Our Ref: SSD 8859

Response to Submissions 1111-1116 Elizabeth Drive, Cecil Park subdivision (SSD 8859)

ATTACHMENT 1 – DEPARTMENT OF PLANNING AND ENVIRONMENT ISSUES

DRAWING TITLE
EARTHWORKS CUT-FILL PLAN

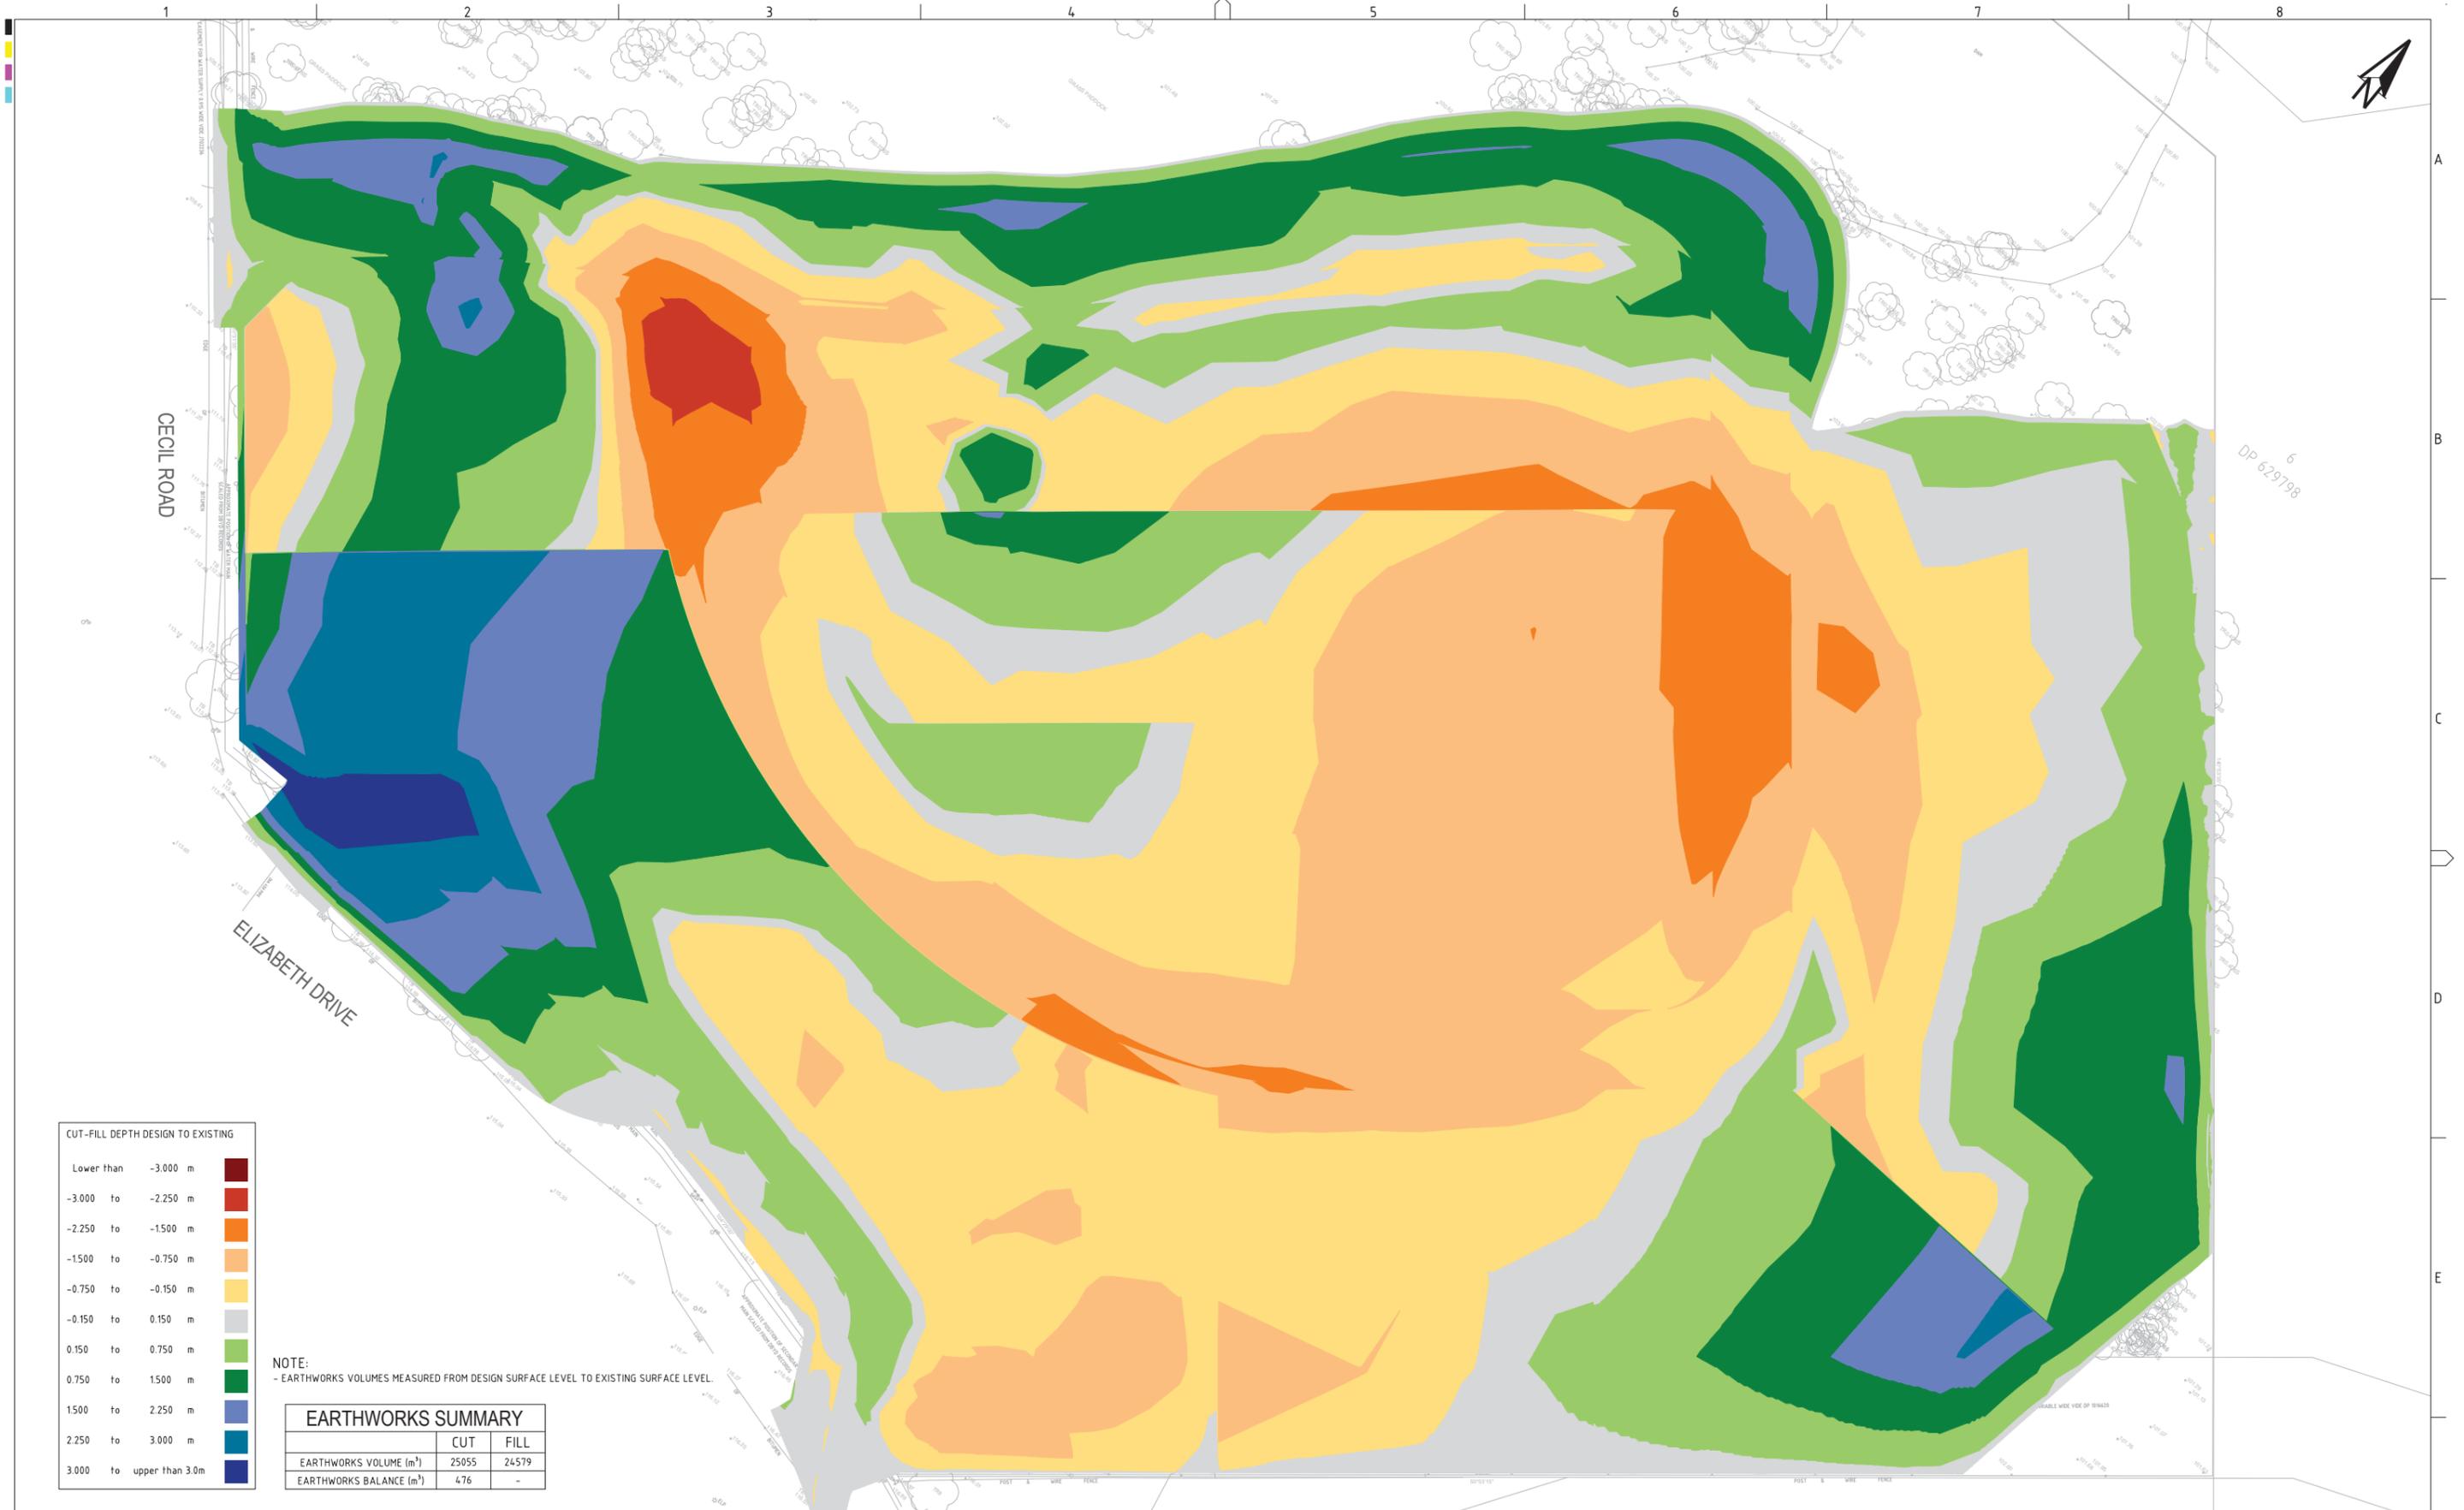
24. Provide a detailed retaining wall plan which shows:
 - a) heights of all proposed retaining walls
 - b) sectional plans
 - c) retaining wall design.
25. Provide a detailed plan showing all cut and fill proposed on site.
